August 2, 2006

Addendum No. 1

RE: Contract ID: C201624
WBS# 35881, 36272
Columbus County
NC-130 from SR 1435 to SECC,
and SR-1552 (Smyrna Rd.) at US 701 Bypass.

PROJECT NO. 35881  
 COLUMBUS COUNTY  
 STATION 32+29.90 - L-Rev.  
 SHEET 3 OF 4  
 STATE OF NORTH CAROLINA  
 DEPARTMENT OF TRANSPORTATION  
 SINGLE 6'-0" X 8'-0" CONCRETE BOX CULVERT 90°-00'-00" SKEW  
 REVISIONS

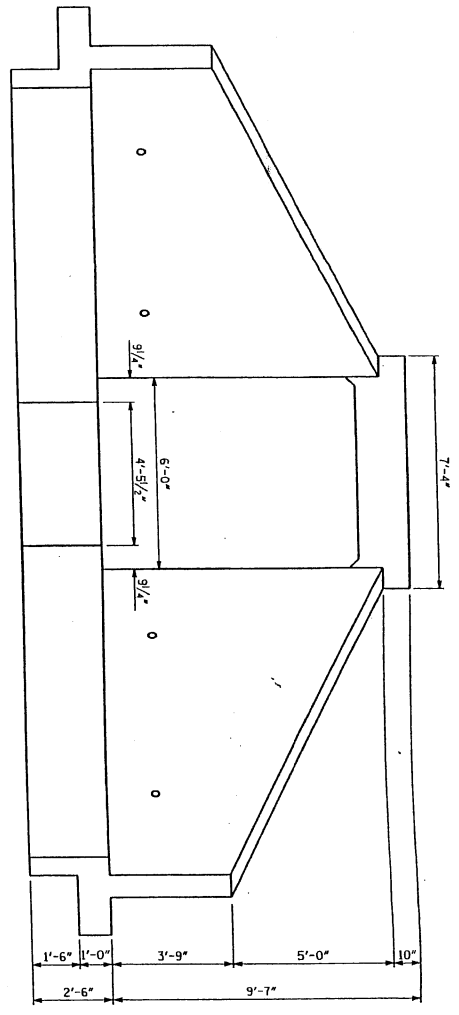
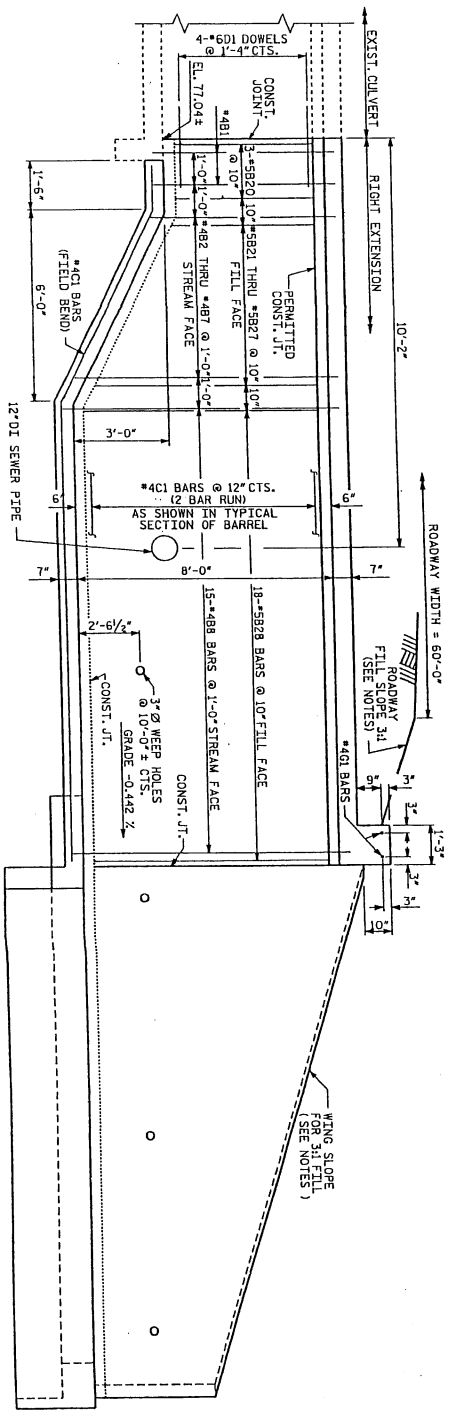
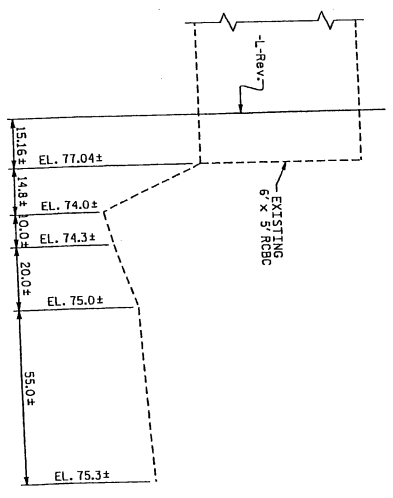
On page no. 5 of the item sheets, line item "79-8196000000-E-420 Class A Concrete (Culvert)" has been revised. By copy of this addendum, the pay item quantity is hereby decreased from "331.9 cy" to "31.9 cy". The Contractor's bid price must be based on the revised pay item quantity. The Contract will be prepared accordingly.
